Figure 2-5 Indicative Construction Access and Compounds (Rev P01)

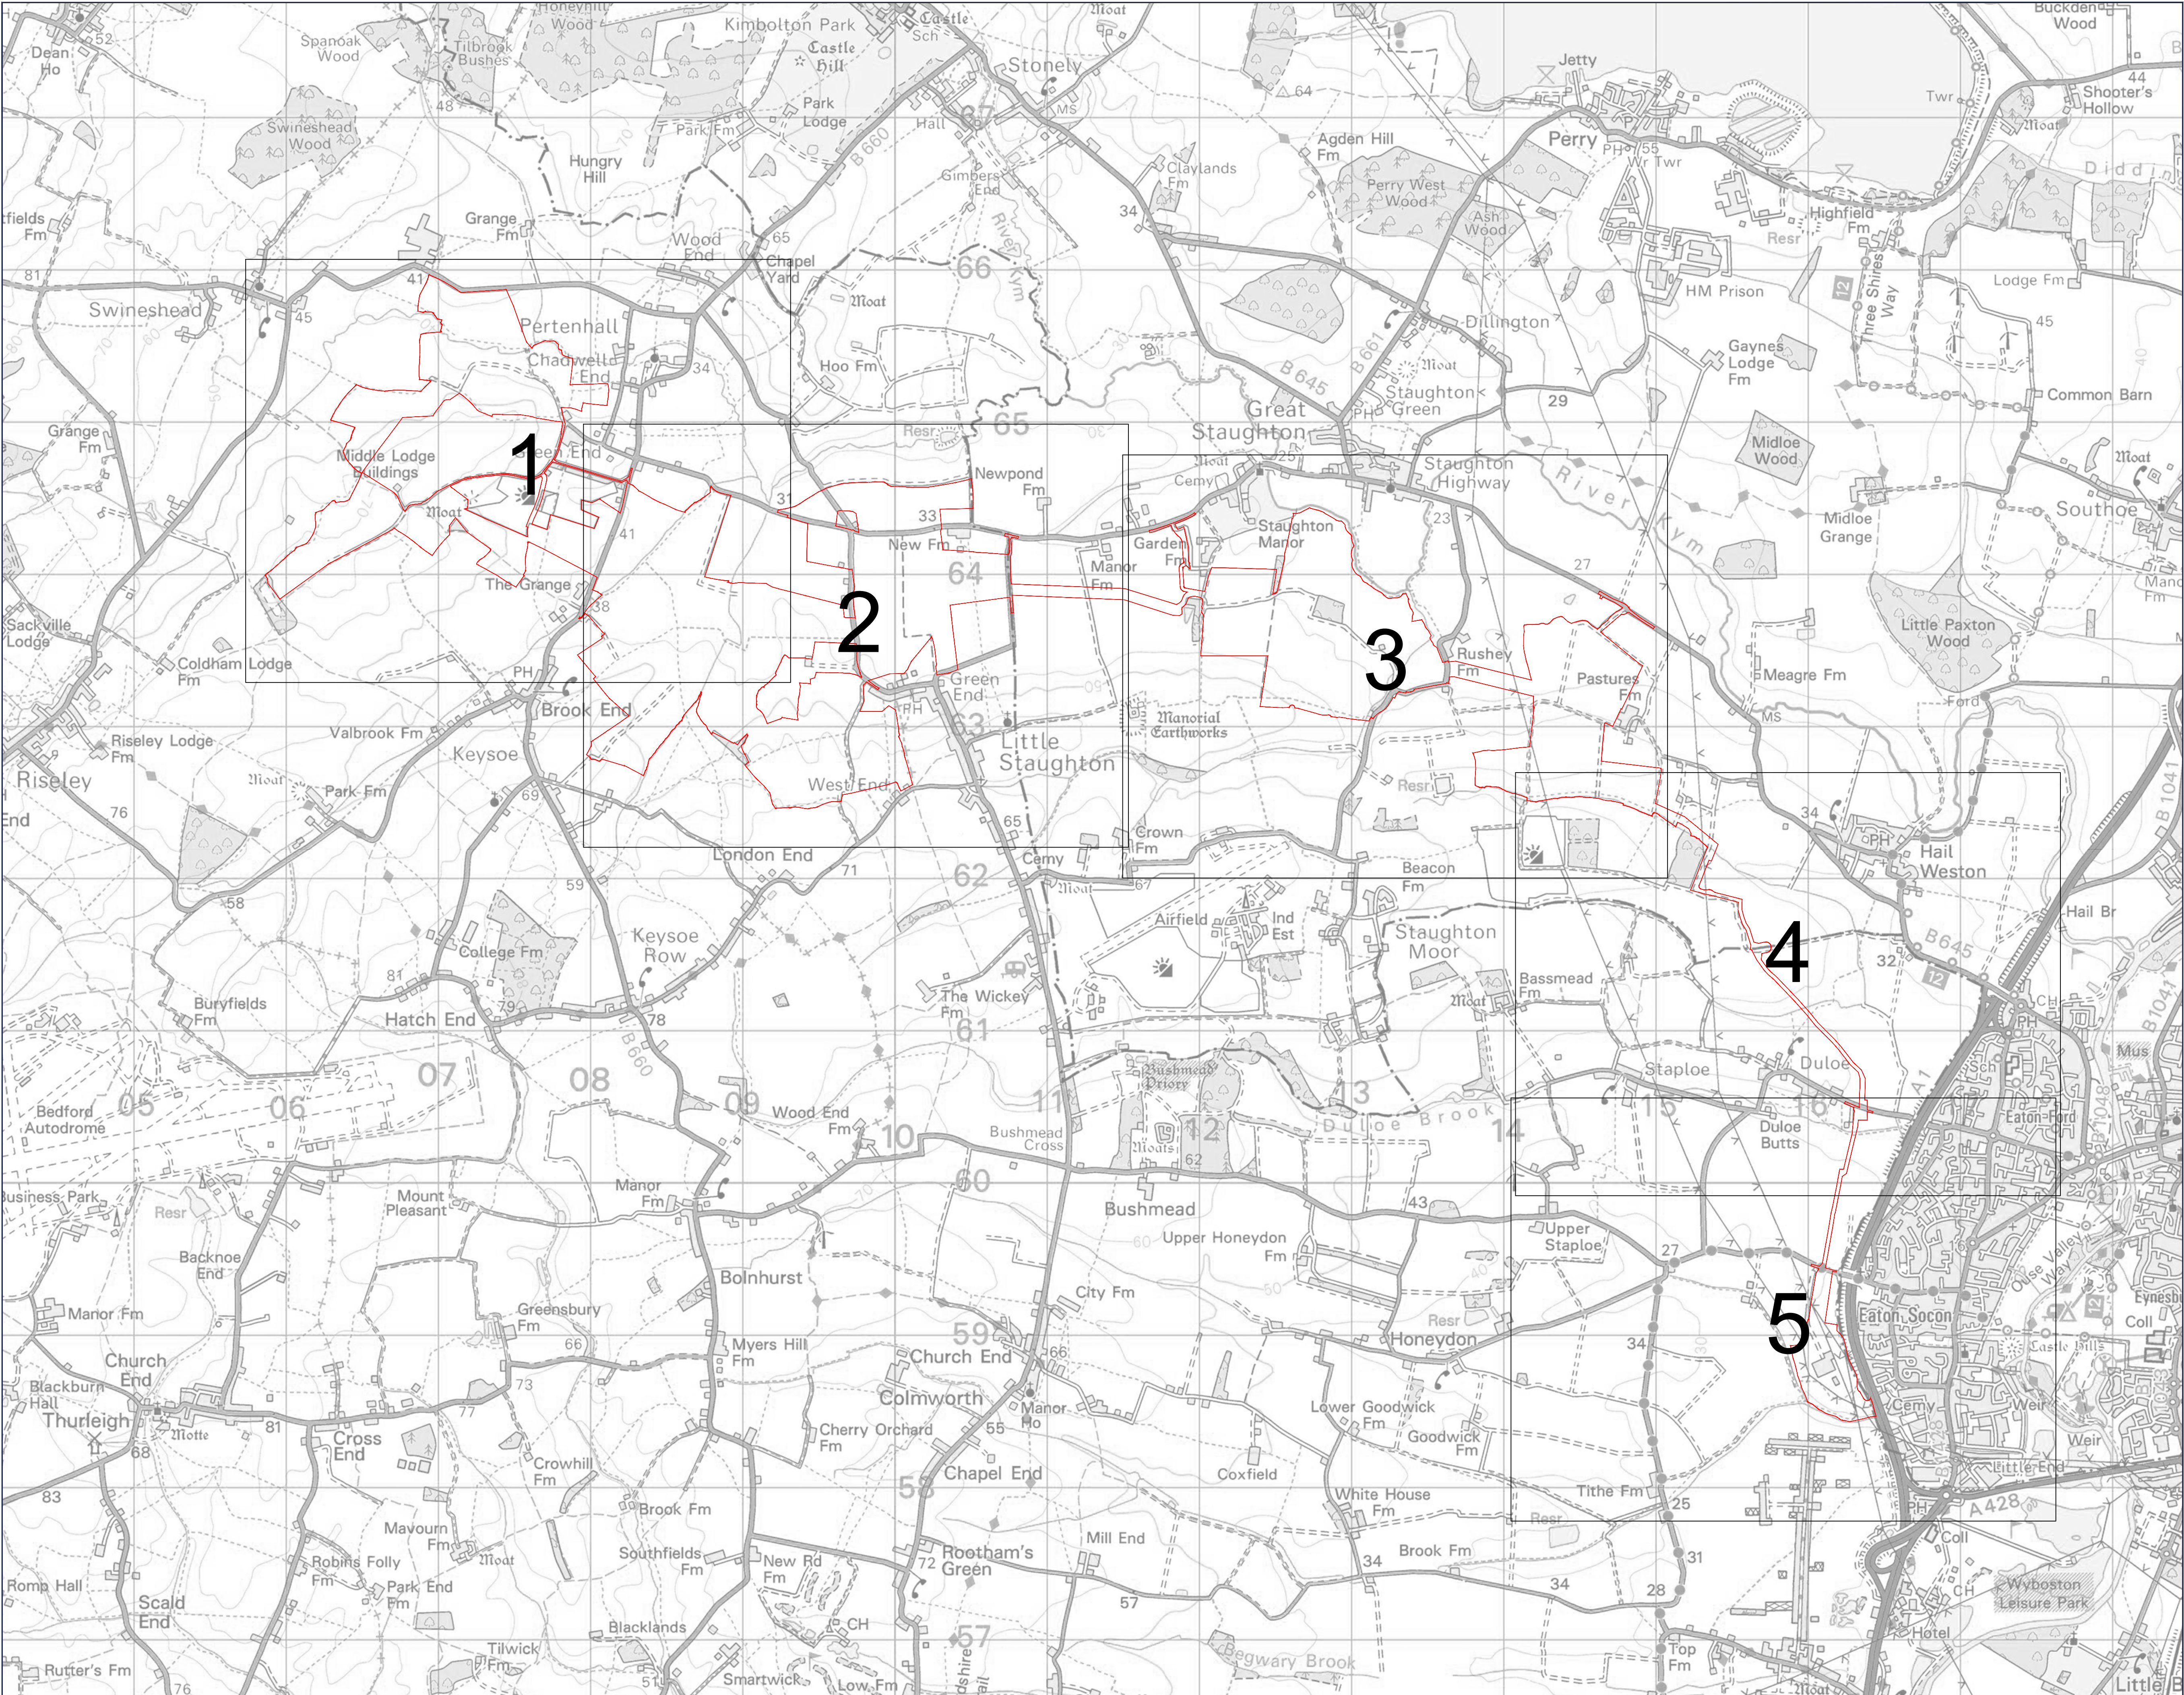
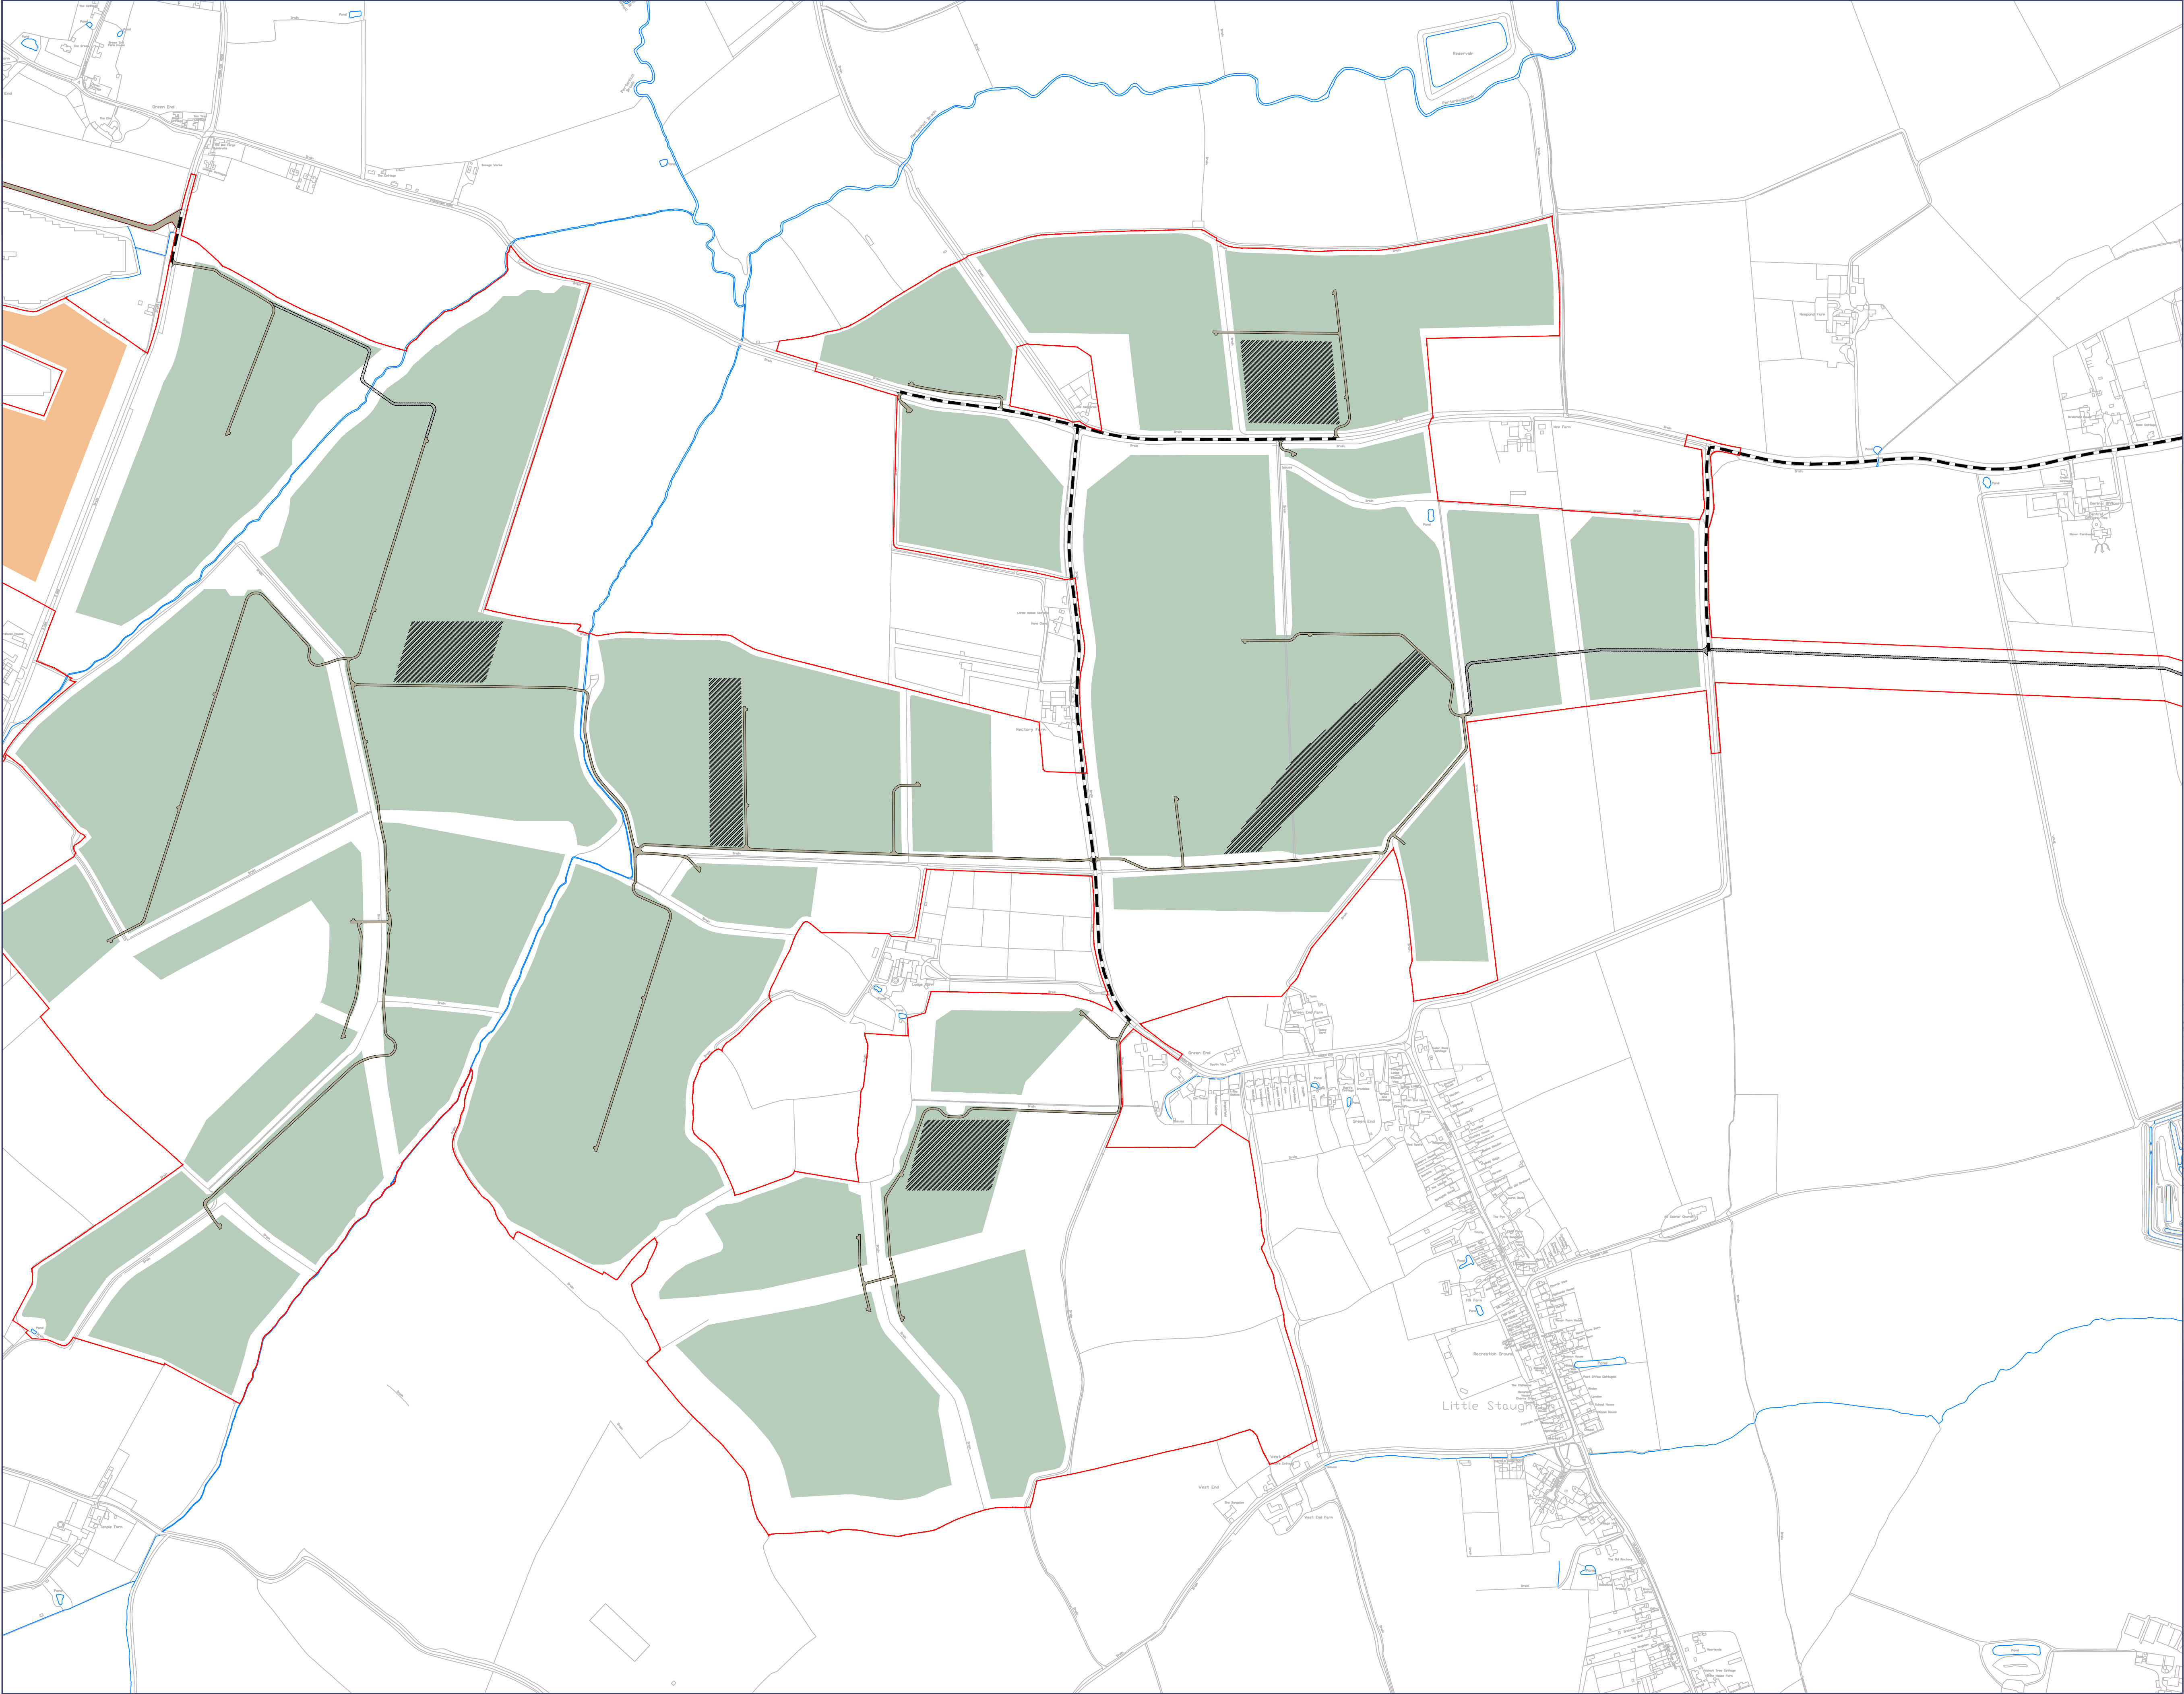
1. High Wood Solar Farm; this is in fact on a very busy B645 on a sharp bend so high volumes of traffic will be extremely dangerous and the path opposite is the only walking route for residents of Hail Weston.

2. Section 2 - Santra access (SA12) Spring Hill to Green End. This road is very narrow with tight blind bends.
3. SA06 access from Green End. This is already a dangerous crossroads at Kangeroo and has cars, bikes, motorbikes, horses and runners going through the junction regularly. The road from Kangeroo to the B645 is already showing as 'unsuitable for heavy vehicles' and two cars are not able to pass each other without slowing right down. Horse lorries have already been stopped from using this road. The plan is for the junction to be used for SA03, SA04, SA05 and SA06. This is a major accident hazard and the narrow roads would mean emergency vehicles could not get through.

4. Green End to Little Staughton. SA08, SA07, SA09 are all by homes. Green End goes through part of the village of Great Staughton next to homes.
5. It is unclear on Section 3 where the traffic is planned. It says turning right but if it is a right turn, how is the traffic getting to Manor Farm.

6. Section 4 Moor Road. This is a very narrow road with dangerous blind bends and is totally unsuitable for the volume of heavy goods vehicles planned.
